# Development Application and Planning Proposal Review NSW Planning Portal Concurrence and Referral

Authority	Authority's Reference	Agency Concurrence and Referral	Authority Contact	Authority Notification	Submission Due	Submission Made
NSW Dept. of Planning, Housing & Infrastructure	SSD-77211717		Thomas Wilson	8/05/2025	6/06/2025	12/05/2025

Address	Land Title
303 Croatia Avenue, Edmondson Park	Lot 303 DP 1259974

Environmental Impact Statement (EIS) for In-fill Affordable Housing Development – Edmondson Park.

Drawing Name
Site Plan

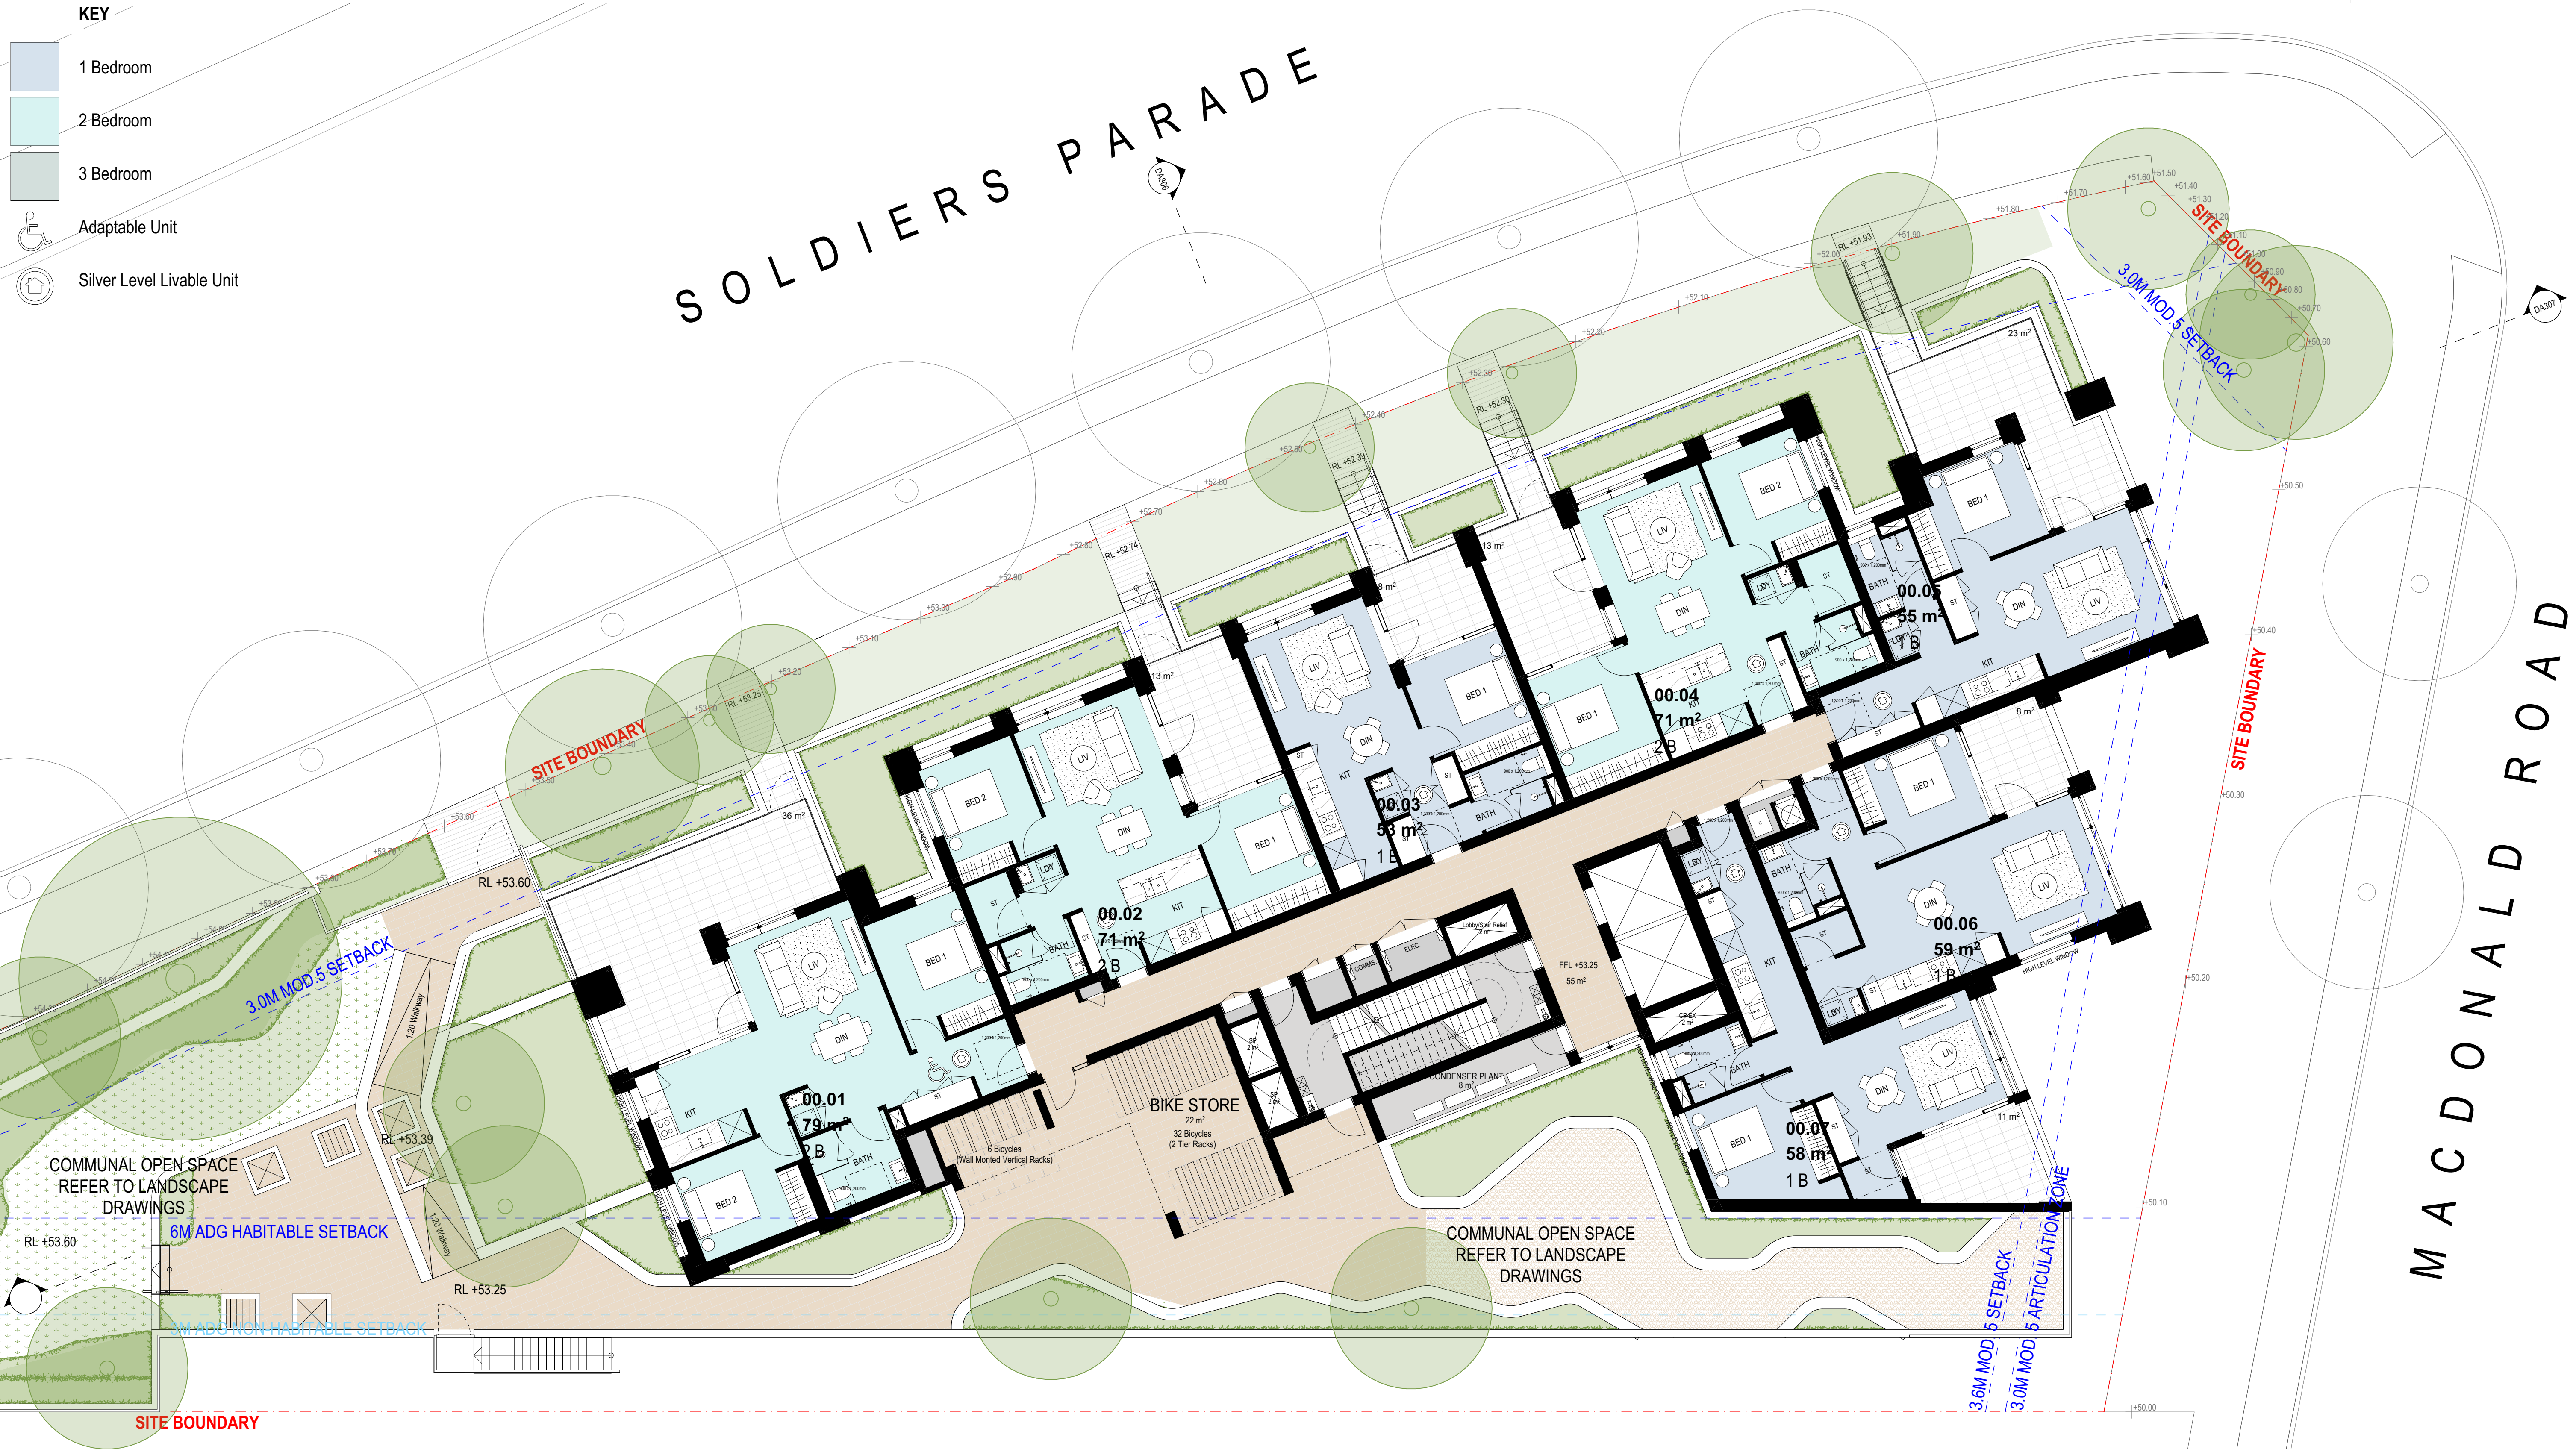
- Any required padmount substation will need to be located within the property (in a suitable and accessible location) and be protected (including any associated cabling not located within a public road / reserve) with an appropriate form of property tenure as detailed in the attached copy of Endeavour Energy's 'Land Interest Guidelines for Network Connection'.

Generally it is the Level 3 Accredited Service Provider's (ASP) responsibility (engaged by the developer) to make sure substation location and design complies with Endeavour Energy's standards the suitability of access, safety clearances, fire ratings, flooding etc. If the substation does not comply with Endeavour Energy's standards, the applicant must request a dispensation.

The below copy of the Site Plan shows provision of a 'Substation' to the Soldiers Parade road frontage.
